Case Officer: Linda Griffiths

Recommendation: Approve

Proposal: Discharge of Conditions 2 (construction of external features), Con 3 (garage construction), Con 4 (enclosure boundaries), Con 5 (Bio-diversity) and Con 12 (Trees) of 19/00895/REM - Reserved matters to 15/01326/OUT - Layout, scale, appearance and landscaping for the residential development of up to 280 dwellings and 34 space car park.

**Drawing Ref**  
BOD BTP 002

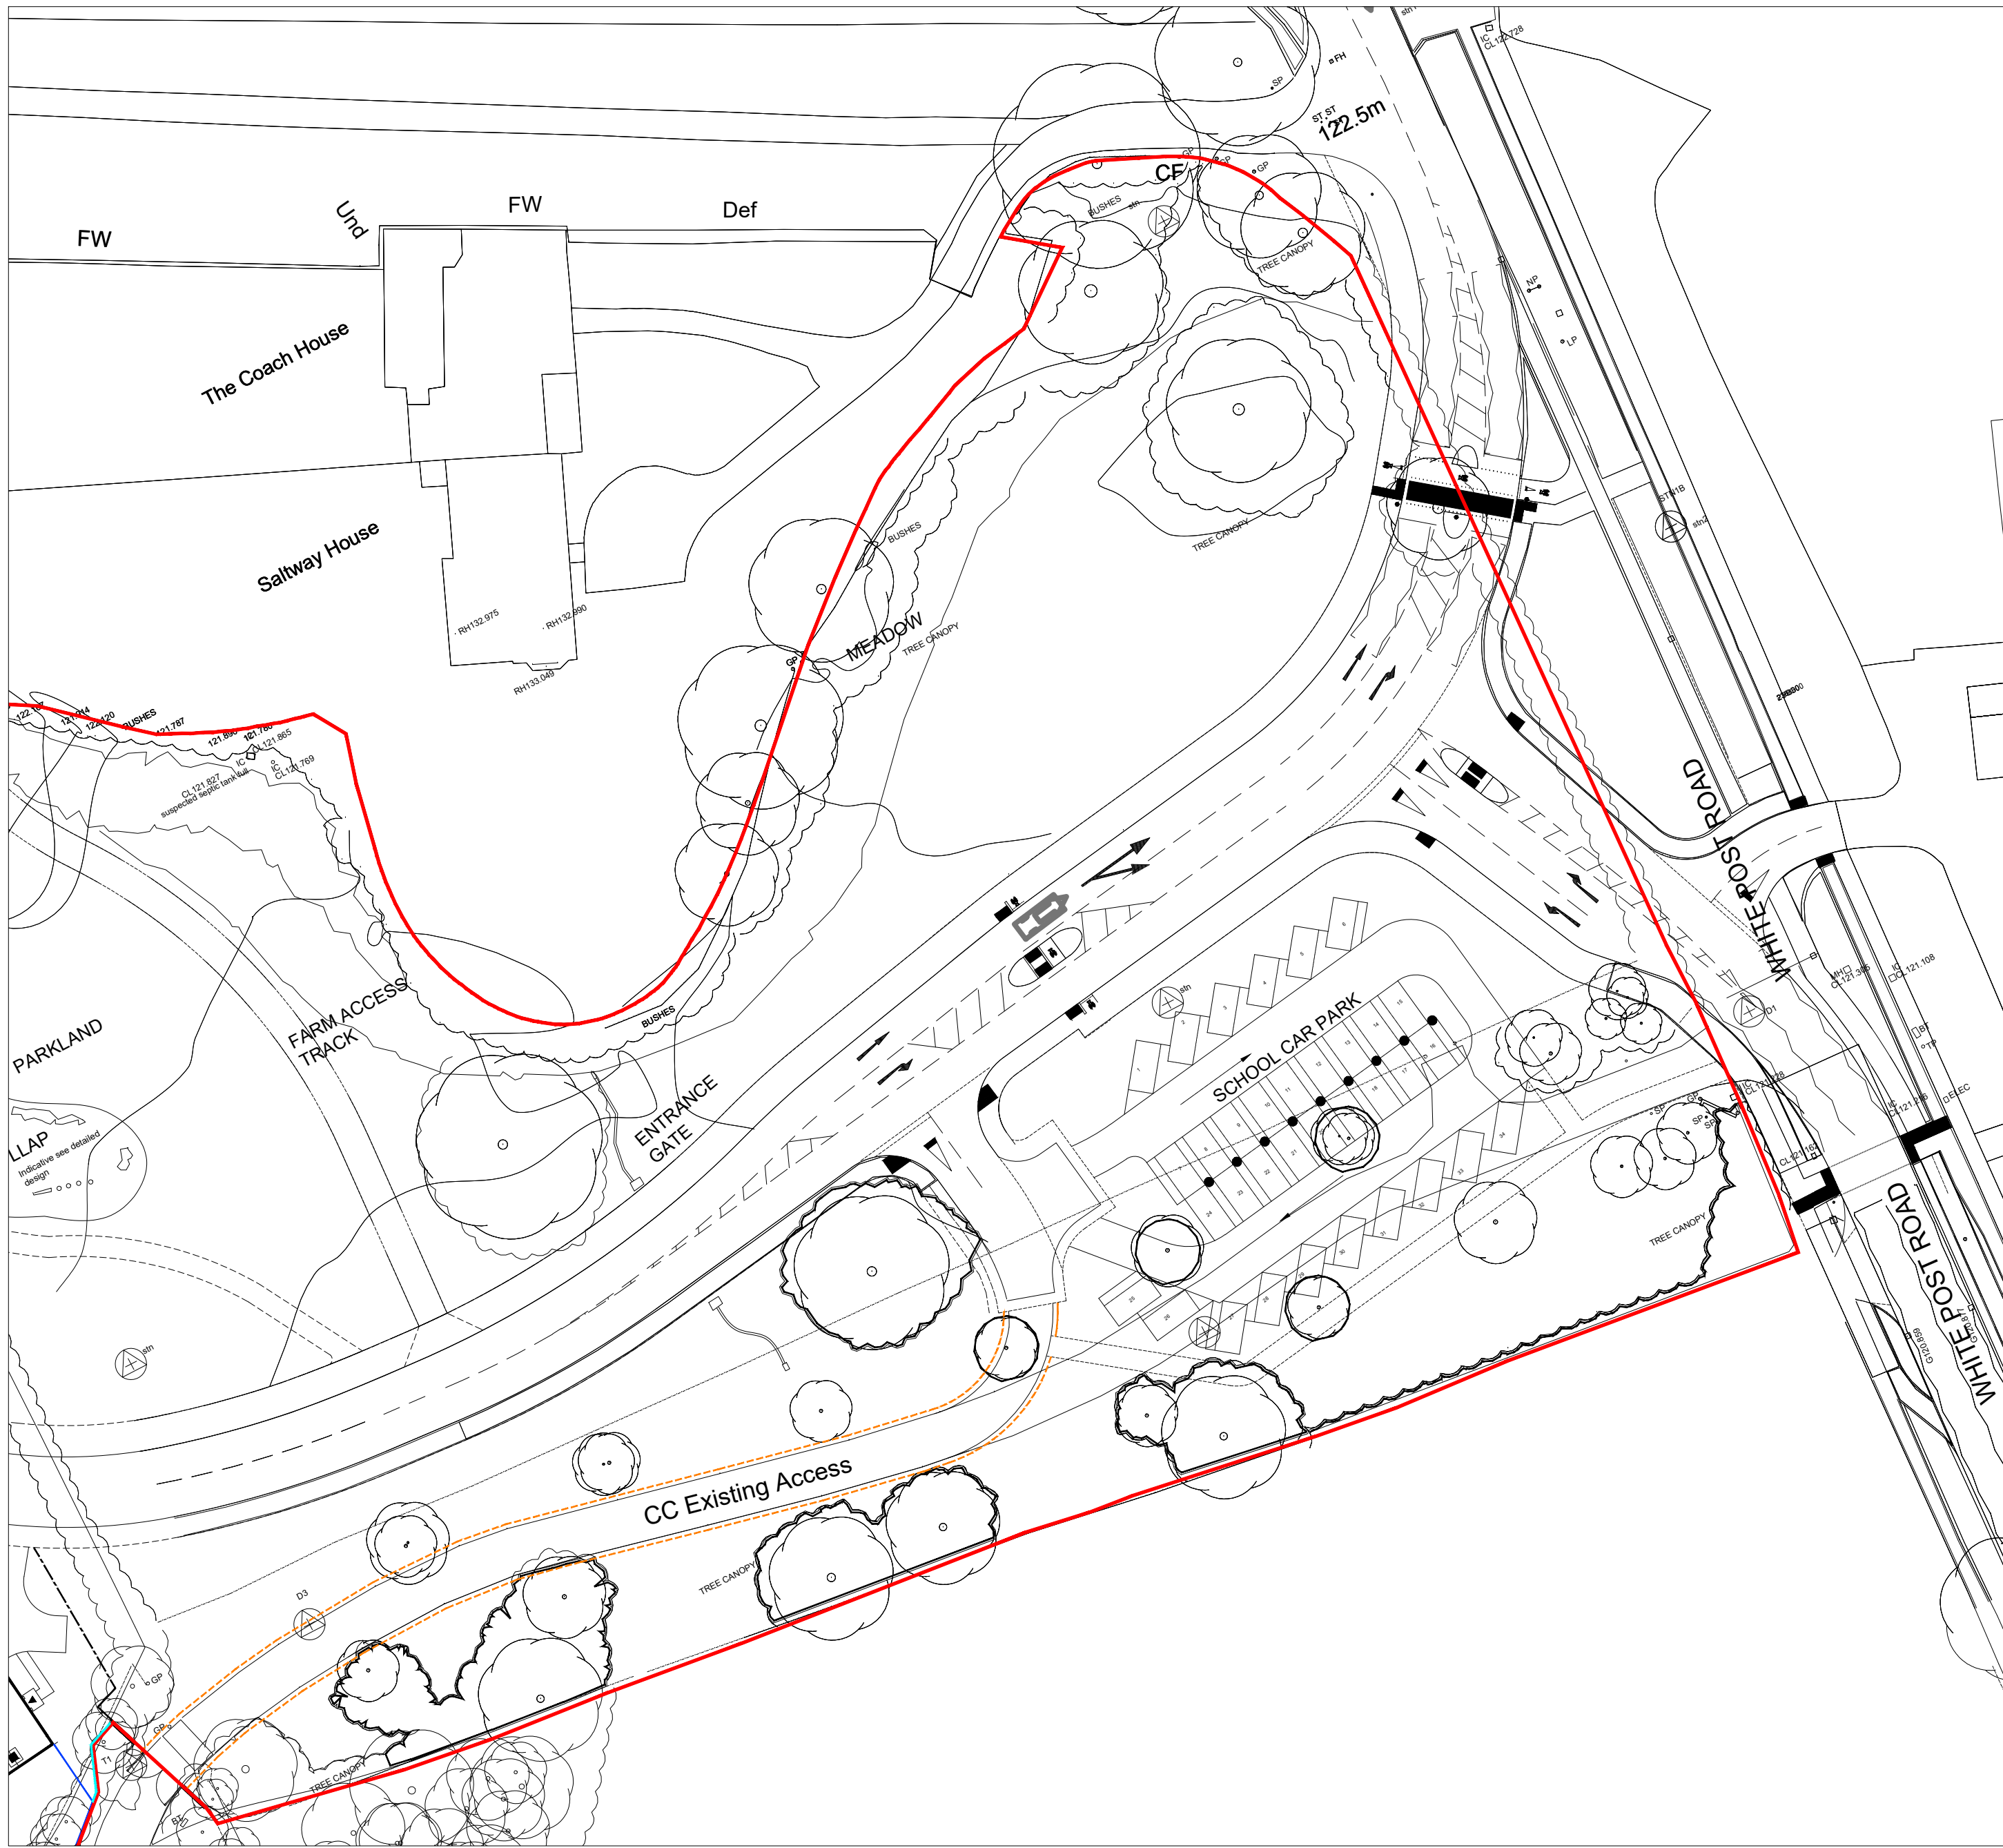
- 5.4 Condition 4 requires the approval of all means of enclosures within the development site to be approved. The plan submitted initially was generally acceptable except that it was considered that the fencing to the southern open space should be removed. This has been done and the submission is now considered acceptable. The condition can therefore be discharged accordingly.
